**New Request for Advice – Kings Park Metal Recovery and Recycling Facility Expansion  
(SSD-10396) (Blacktown)**

## **TAB A - TfNSW comments on SSD-10396 Kings Park Metal Recovery and Recycling Facility Environmental Impact Statement**

Figure 3.7: Traffic Turning Movements – Saturday Midday Peak

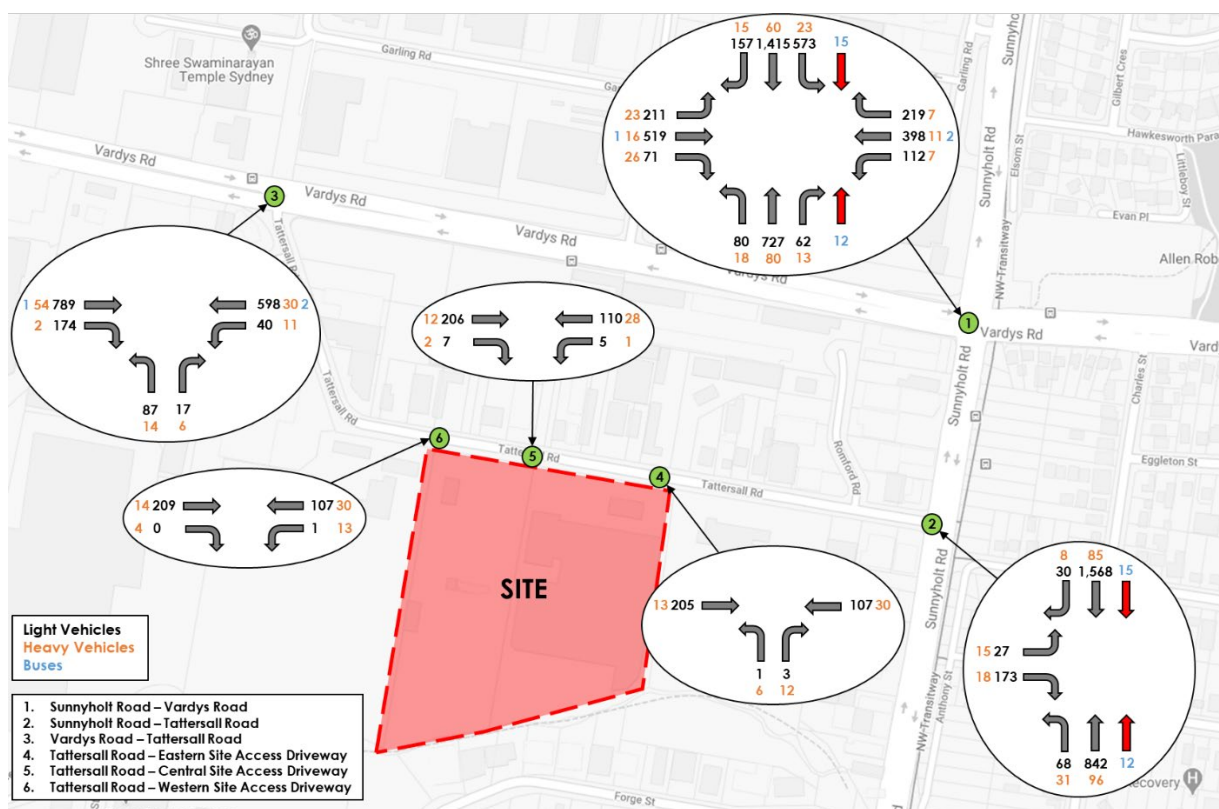
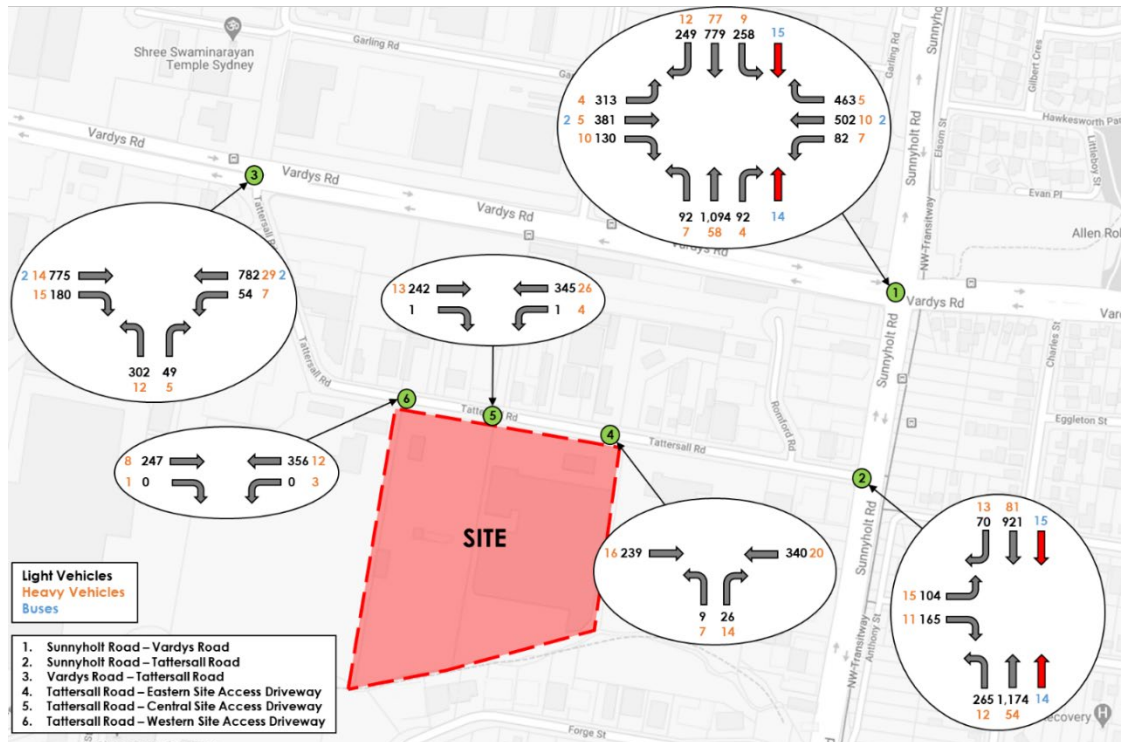
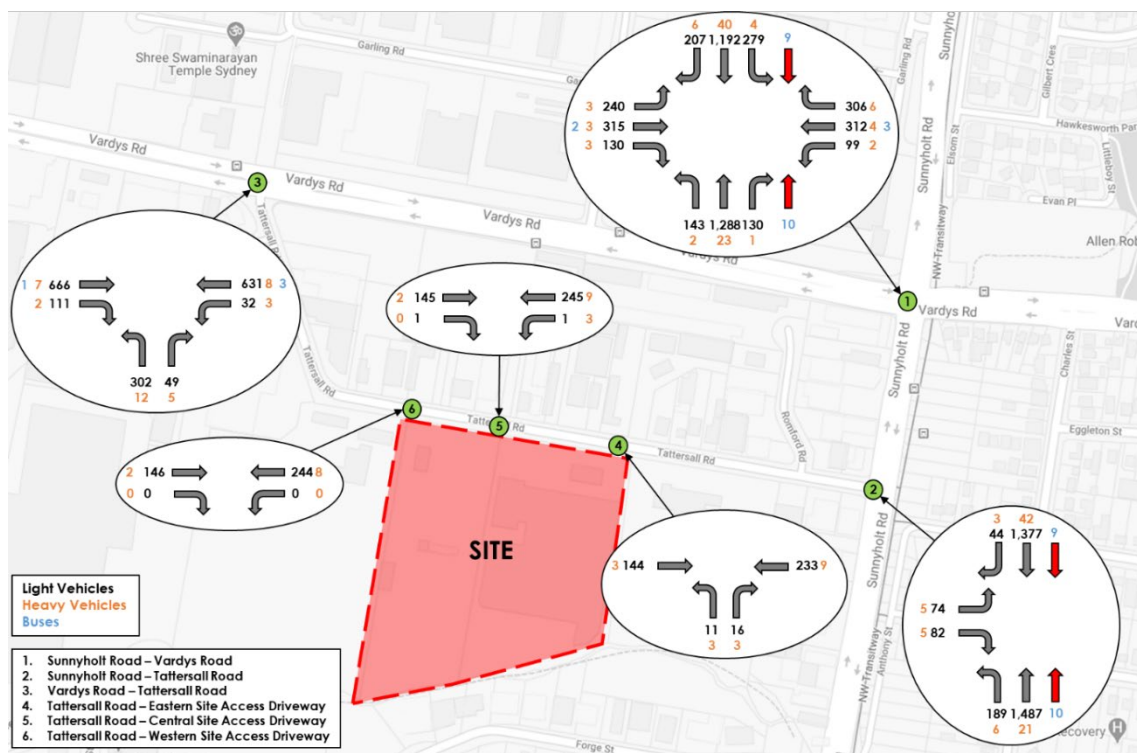
The TTIA appears to contain some inconsistencies in the number of heavy vehicle turn movements presented in Figures 3.5-3.7 vs Table 5.3 of the report (for example: Saturday Peak: Outbound heavy vehicles shown in Figure 3.7 as 6 vs 8 in the report).

It is requested that the TTIA be revised to clarify the consistency of the volumes presented in the Figures vs the Tables.
